City of Albuquerque Stormwater Construction Site Inspection Report

ESC File No.	H10E030	Project Name:	Albuquerque RV & Boat Storage		
NPDES Id. No.	NMR1000K2	Location:	2201 Vista Oriente St. NW		
8/30/2021	Owner			Contractor	
Operator	Ladera Enterprises				
Contact name & title	Dan Rich, Principal		Leonard Bridge		
e-mail	emeraldprops@aol.com		leonardbridge2@gmail.com		
Contact Phone #	505-304-4516		505-550-7033		
COA Inspector	Doug Hughes		Start/End Time:	2pm	
Construction Phase:	Excavation/grading				
Type of Inspection:	Regular	Storm Event	Past Storm Event >0.25"	311/Complaint	Follow Up
Weather at time of inspection?		clear		Temperature: ~	93
Estimated date of last storm 0.25" or greater			7/31/2021

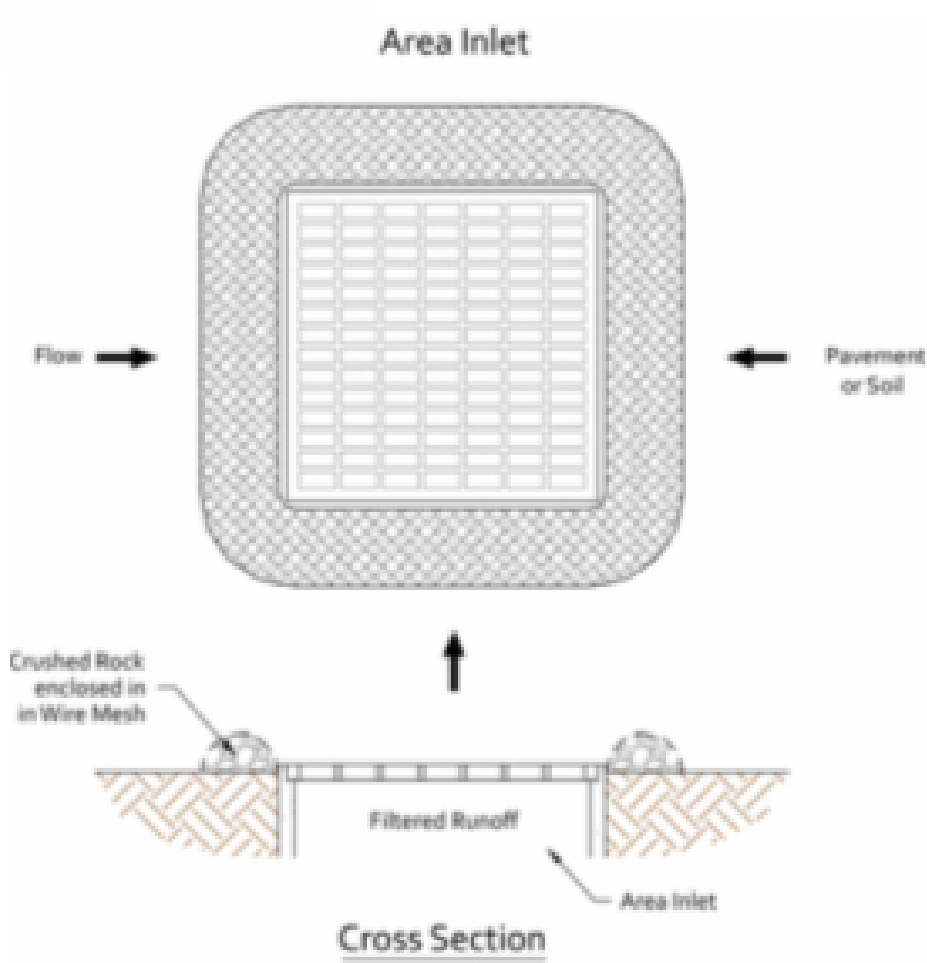
Item Number	Deficiency/ Corrective Action				
1	Washout in NE corner missed the liner and is laying on the ground. Pick up washout and dispose in proper waste container. Move Washout container to high ground.				
2	SWPPP was still not on site. The SWPPP must be up-to-date and available onsite at the next inspection.				
3	Silt Fence is not adequate for this large of a drainage area. Revise the BMPs to add properly sized diversion and sediment traps along the east boundary.				
4					
5					
6
